**From:** Janice Chapman  
**Sent:** 21 August 2014 10:01  
**To:** 'chris barrow'  
**Subject:** BE/76/14/HH - Loft conversion with rear dormer at 6 Greystone Avenue, Bersted

ELEVATIONS & SECTION B-B AS PROPOSED

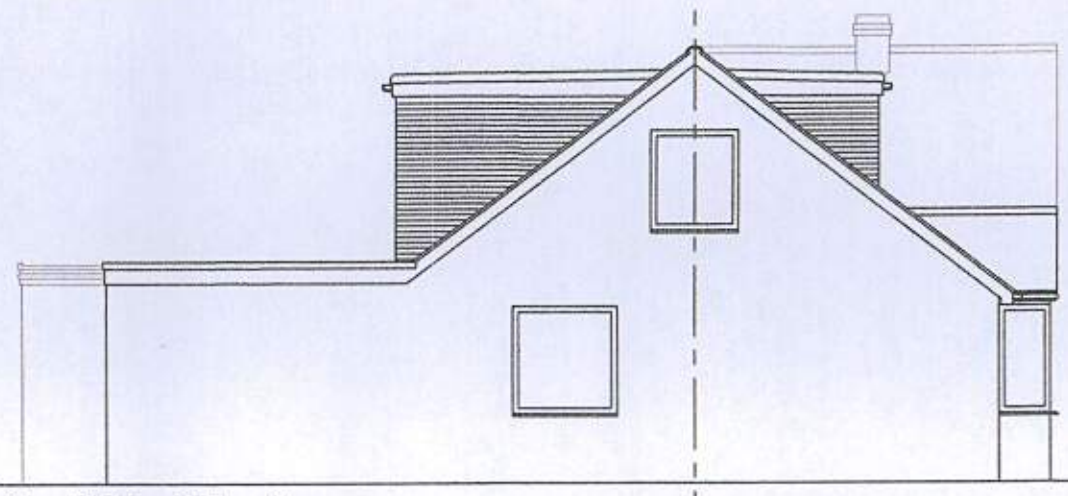
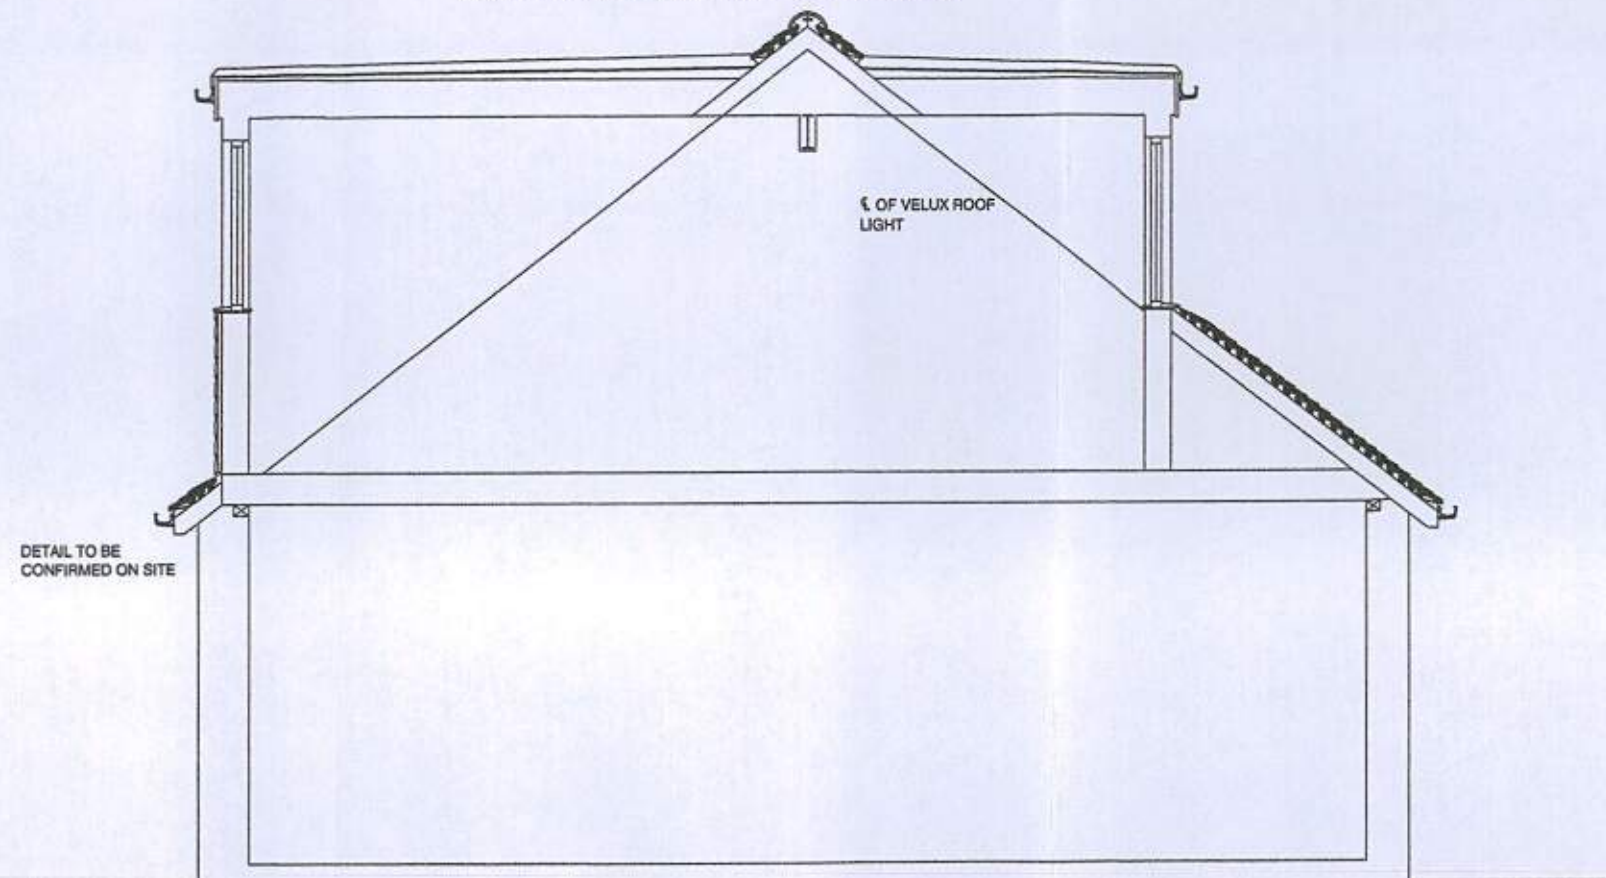
I am aware that the front dormer is clad, however, the application forms states that the rear dormer will be tile hung. Drawing No Elevations & Sections 1074-05 states that the rear dormer is to be clad with white weatherboarding. In view of its size and height I consider that this should be tile hung to match the existing roof.

Please confirm.
